TO: Robert Heiser and Saige Cox / Studio Southwest Architects
FROM: Sergio Lozoya, Current Planner
City of Albuquerque Planning Department
TEL: (505) 924-3349
RE: AA PR-2021-005746 – SI-2022-00947 5800/5900 Jefferson St. NE

I am the Staff Planner reviewing your application for project # PR-2021-005746, an Administrative Amendment at 5800/5900 Jefferson St. NE – XRANM, for parking and site improvements.

SHEET TITLE
SITE DETAILS - EQUIPMENT YARD

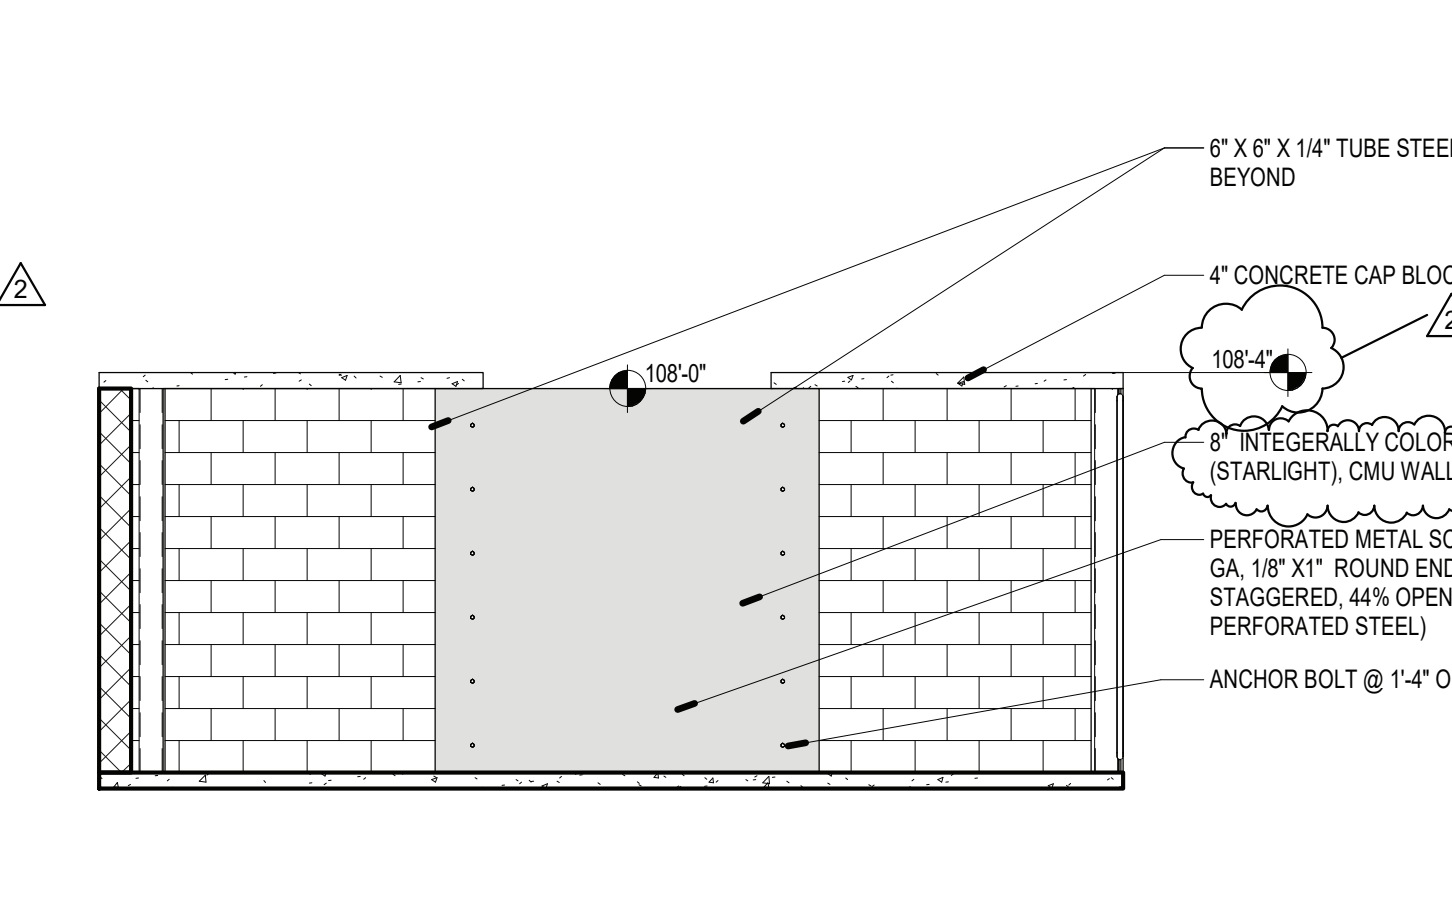
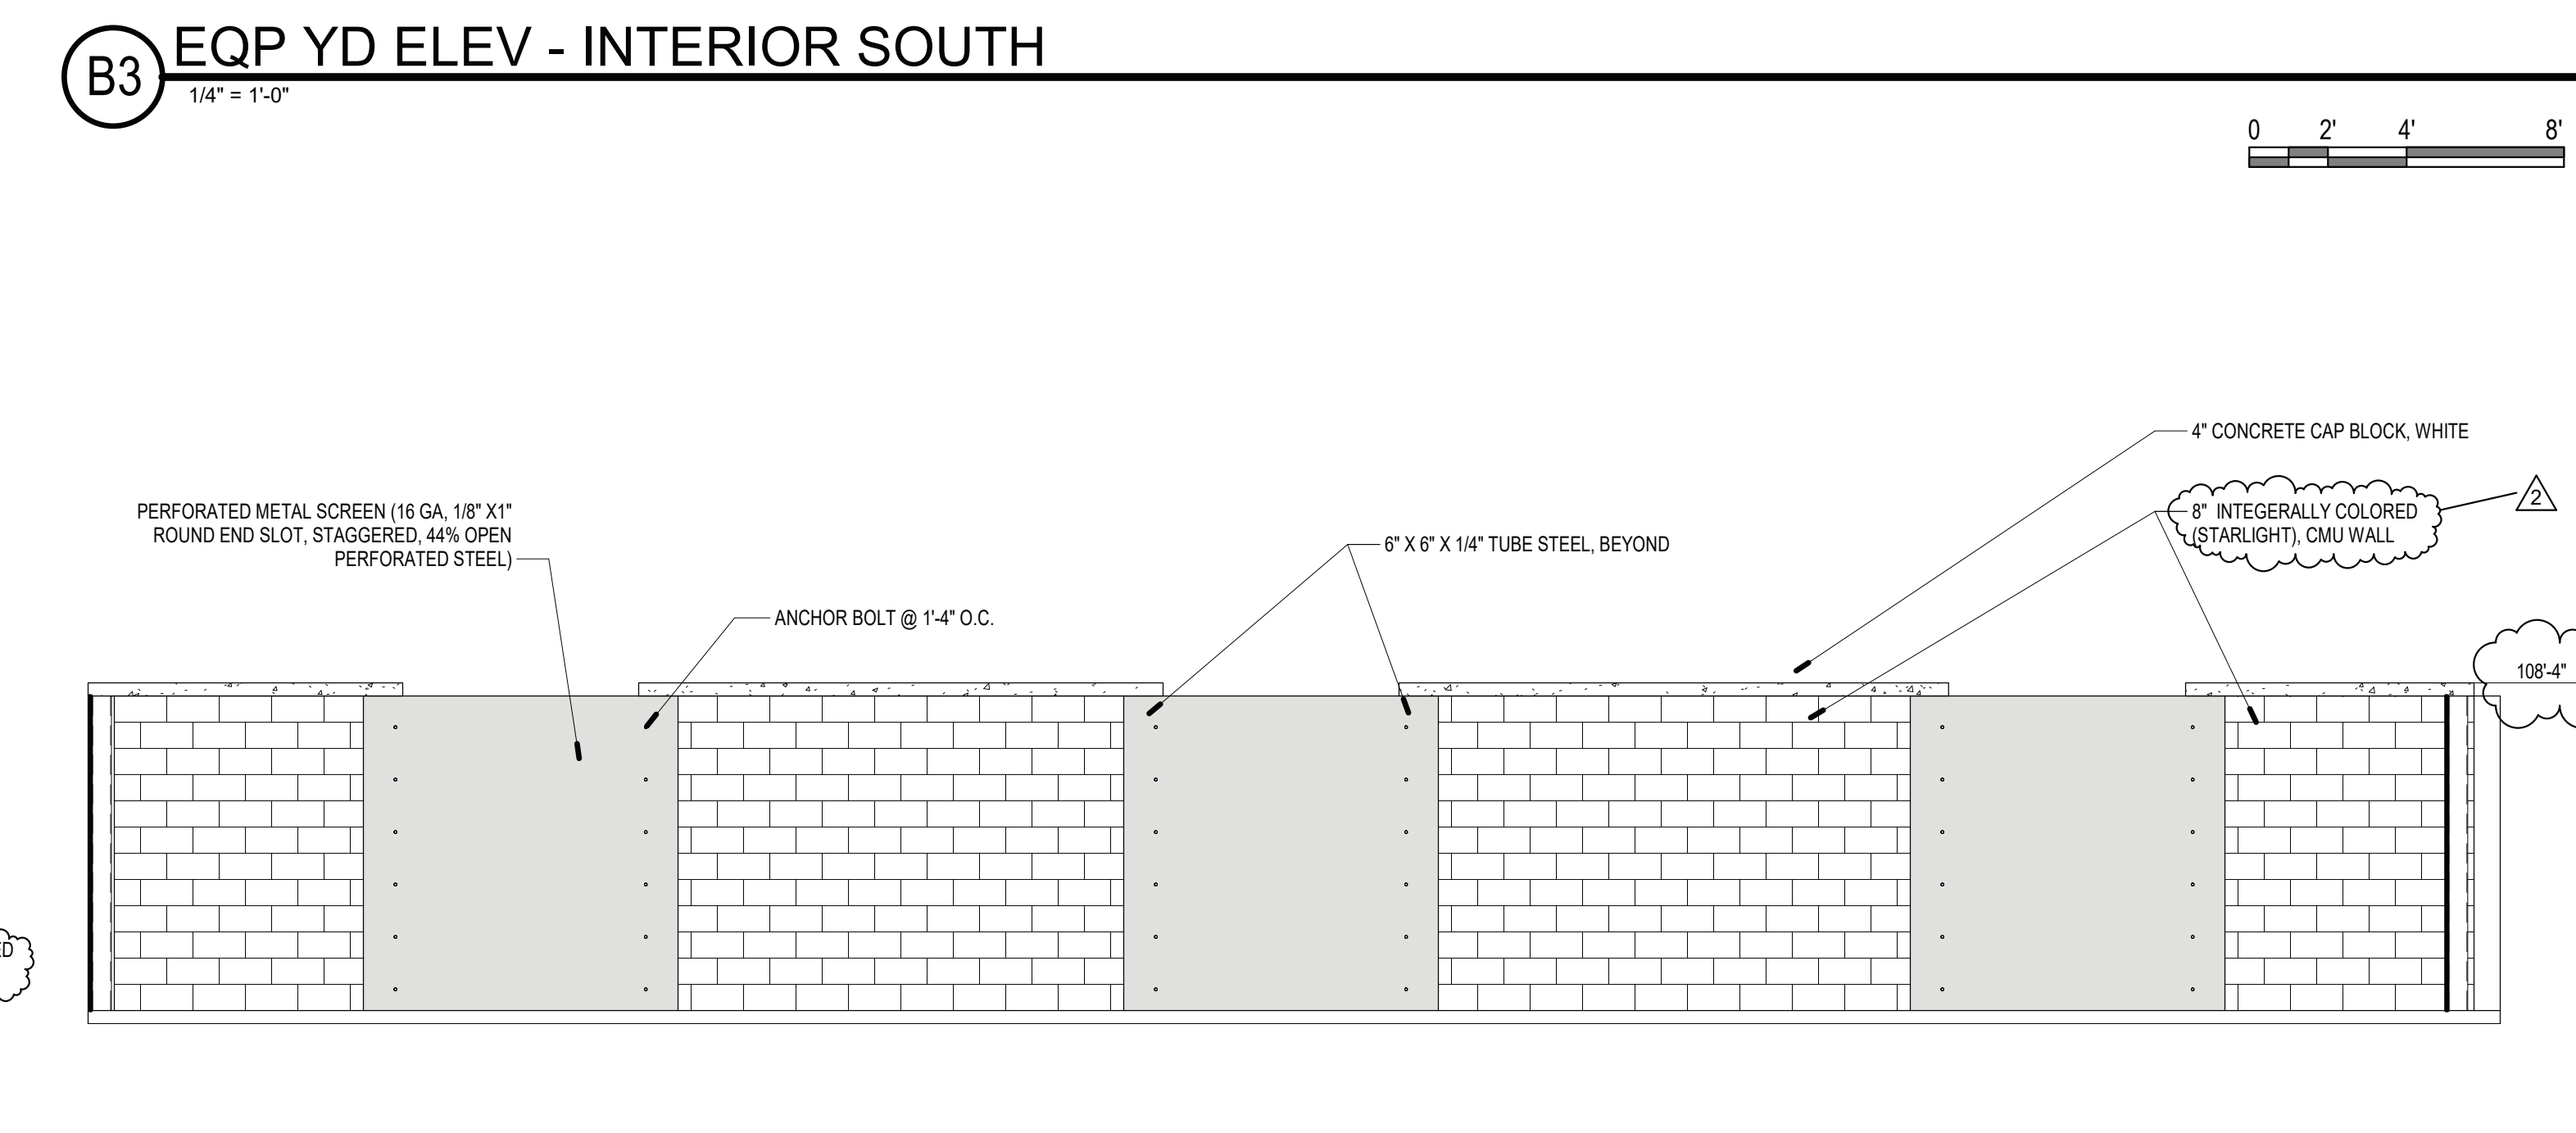
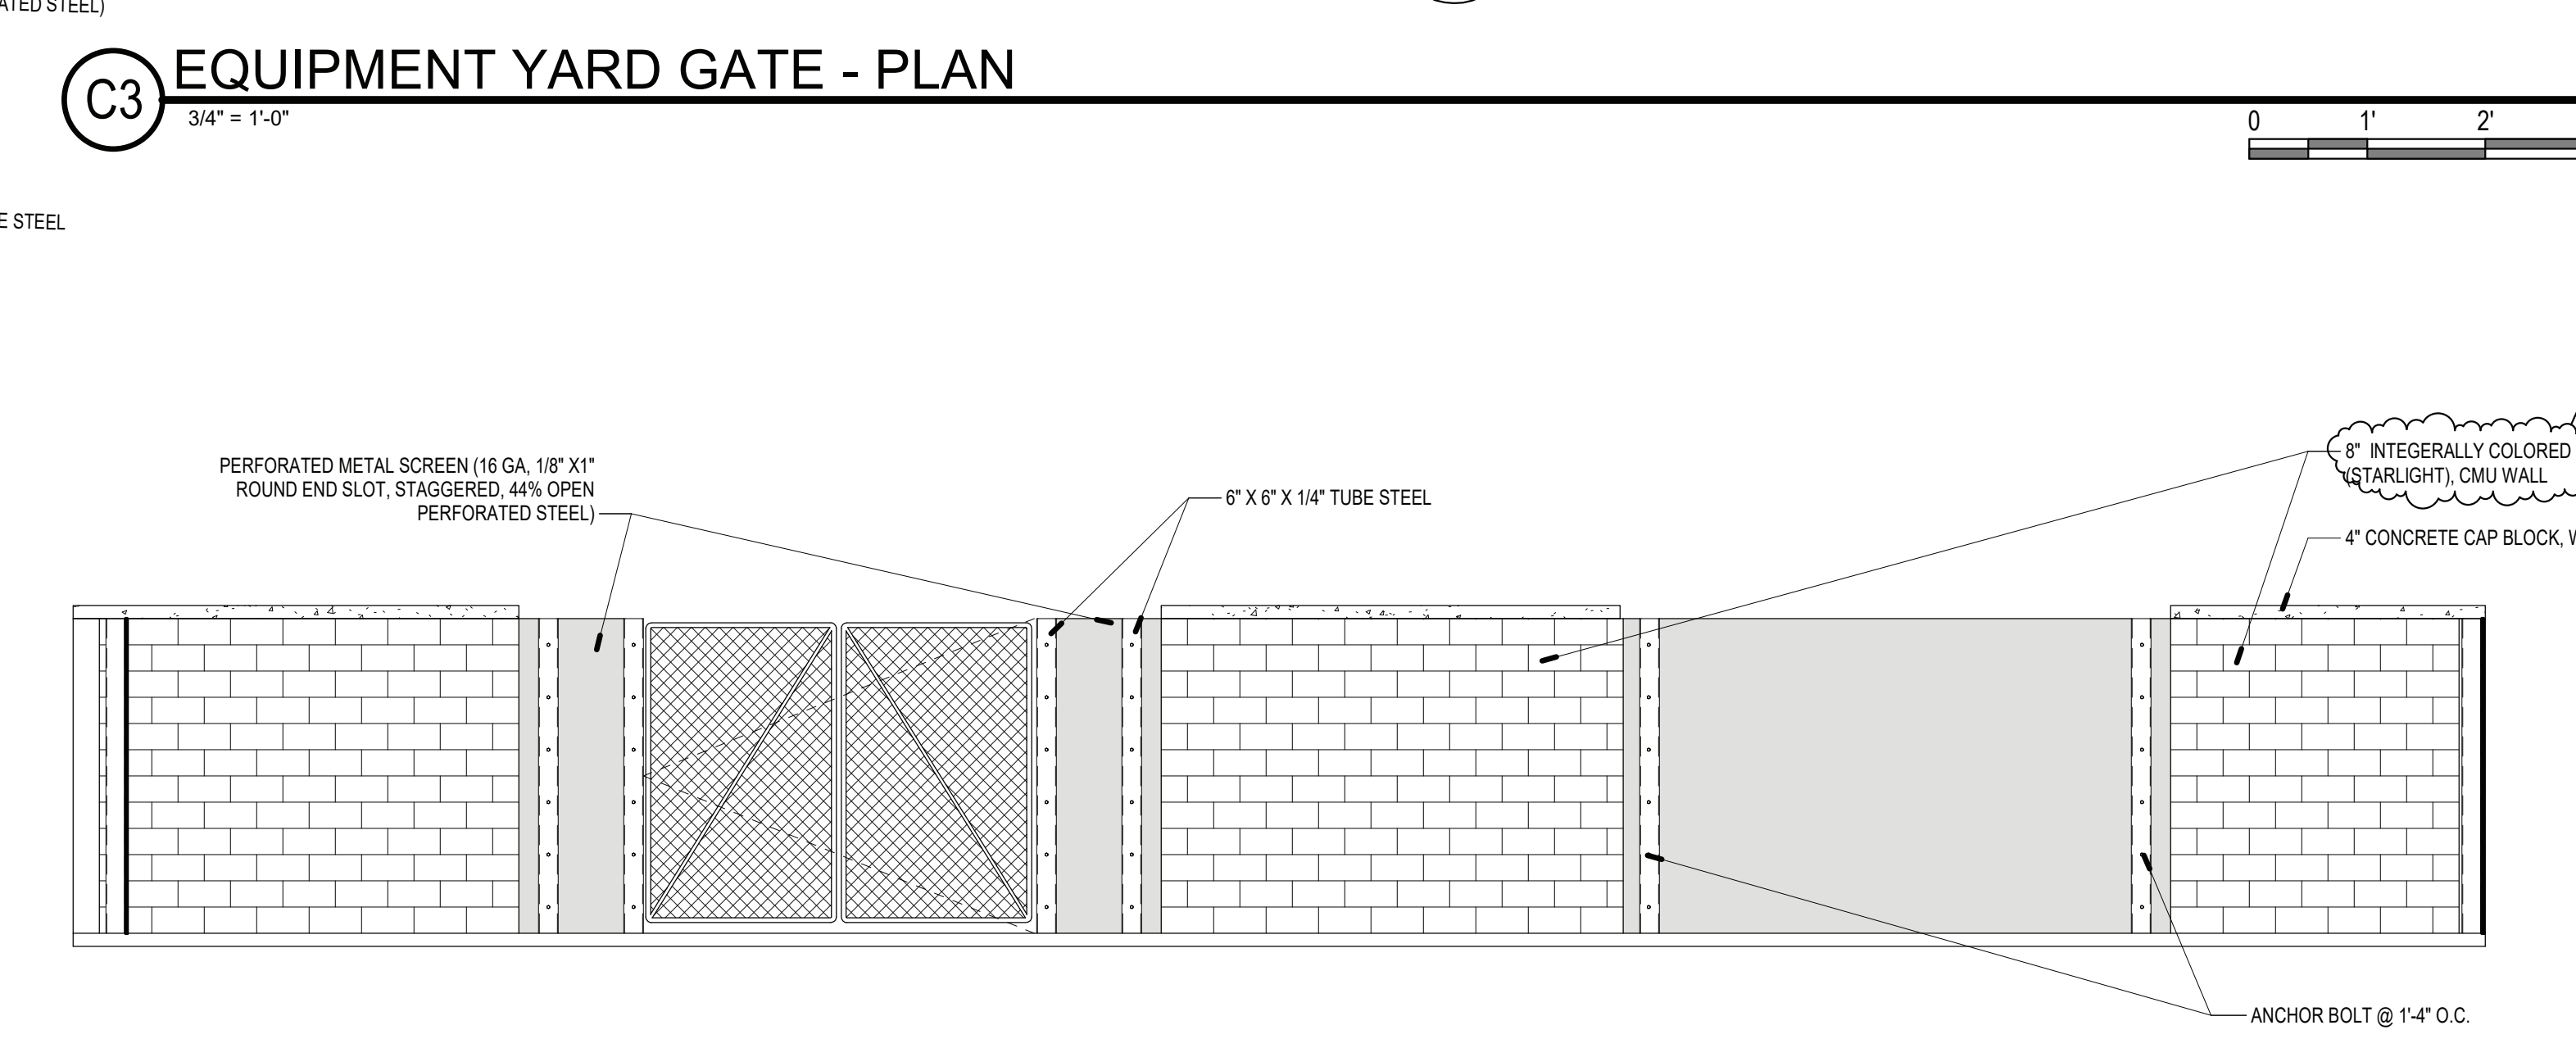
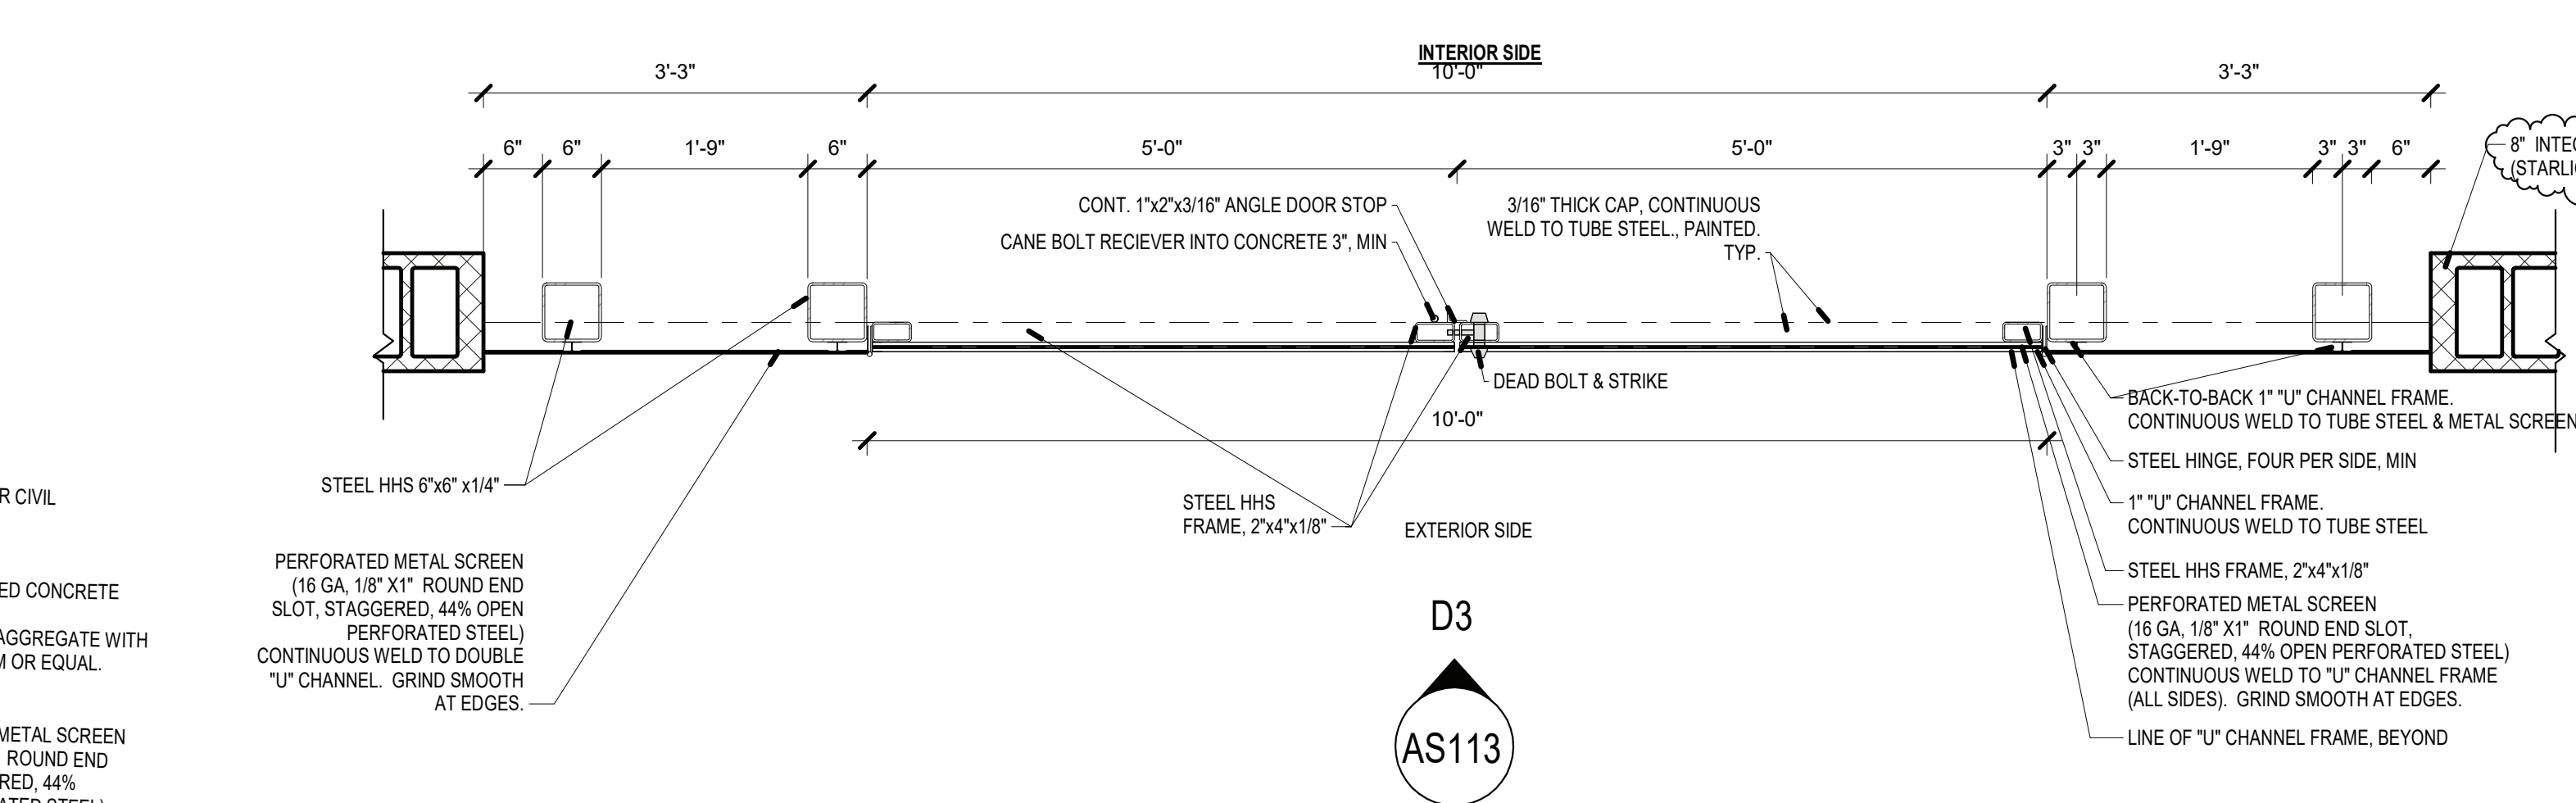
The change in height for the equipment yard wall from 12'-6" to 8'-6" exceeds the allowable 6" change pursuant to the provision shown above (IDO Table 6-4-4 Allowable Minor Amendments).

If the change to wall height is desired, this application will have to be processed as a Major Amendment, and would return to the original approving body (DRB). This application can proceed as a Minor Amendment if the wall height remains within the allowable Minor Amendment thresholds.
